WEST SUSSEX COUNTY COUNCIL CONSULTATION

TO:	Arun District Council FAO: Amy Myer
FROM:	WSCC - Highways Authority
DATE:	17 March 2020
LOCATION:	Tile Barn Farm, 32 Hill Lane, Barnham, PO22 0BL
SUBJECT:	BN/24/20/PL Erection of 1 No. dwelling & formation of new vehicular access. This application is a Departure from the Development Plan.
DATE OF SITE VISIT:	N/A
RECOMMENDATION:	Advice
S106 CONTRIBUTION TOTAL:	N/A

PROPOSED SITE
Dwg. No. 06

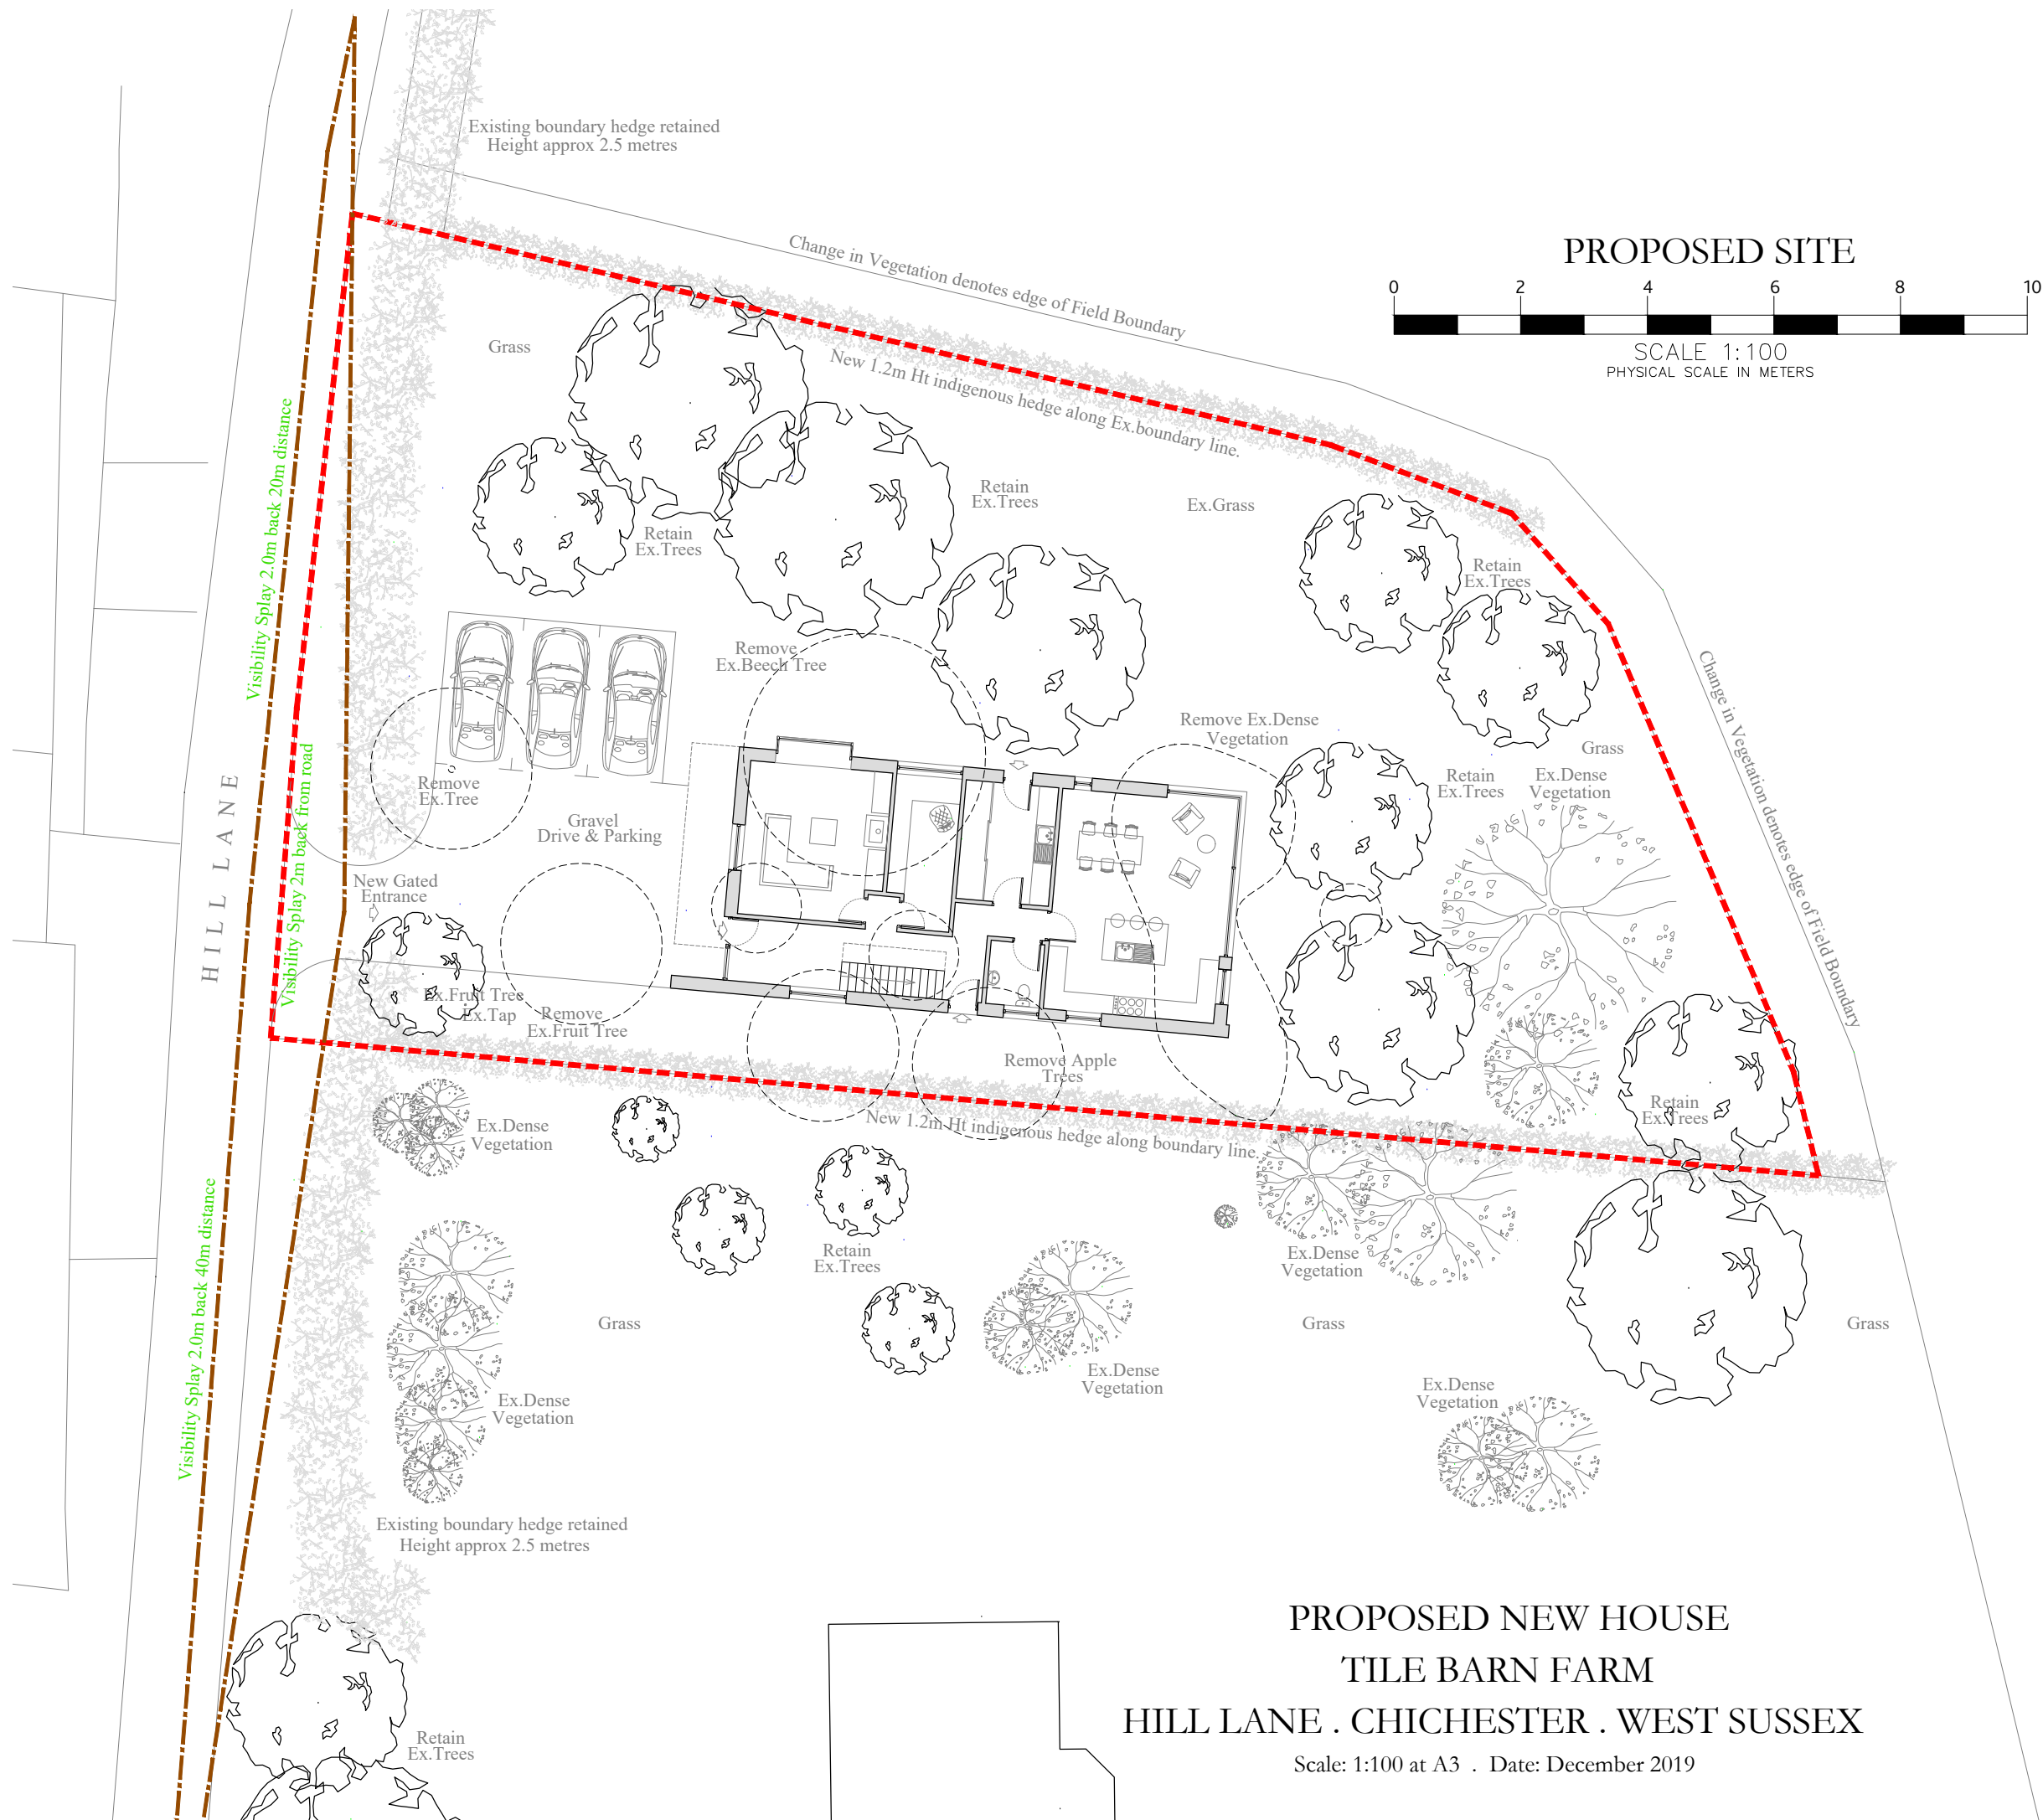
The applicant proposes a new 3m wide vehicular access onto Hill Lane. The LHA advises the applicant to contact the proprietor of the privately maintained lane, to obtain formal approval for the proposed access works. The applicant had demonstrated visibility splays of 2m x 20m to the north and 2m x 40m to the south at the proposed access. Taking the road layout, geometry and anticipated road speeds into consideration, the LHA considers these splays to be acceptable.

The application form states that two car parking spaces are proposed for this development. However, an inspection of the site plan suggests there is actually room for three parking spaces. Under Arun Parking Standards, a dwelling of this size in this location should provide parking provision for at least three cars. As such, the LHA considers the available parking to be sufficient.

From inspection of the plans, it would appear that there is room for on-site turning to be achievable, but by using a multi-point manoeuvre. Manual for Streets (MfS) states that car parking spaces require at least 6m of space behind them in order for a vehicle to manoeuvre in and out. The plans demonstrate space of approximately 5.6m. The LHA advises the applicant to consider widening the driveway to allow for this space, or install a turning head. Notwithstanding this, the LHA is satisfied that vehicles can turn and exit in a forward gear.

In terms of cycle parking, the applicant had demonstrated a cycle store with provision for two cycles. This is in accordance with Arun and WSCC standards. The inclusion of secure and covered cycle parking helps promote the use of sustainable, alternative modes of transport to the private car.

No part of the development shall be first occupied until covered and secure cycle parking spaces have been provided in accordance with plans and details submitted to and approved by the Local Planning Authority.

No part of the development shall be first occupied until the vehicle parking and turning spaces have been constructed in accordance with the approved plan. These spaces shall thereafter be retained for their designated use.
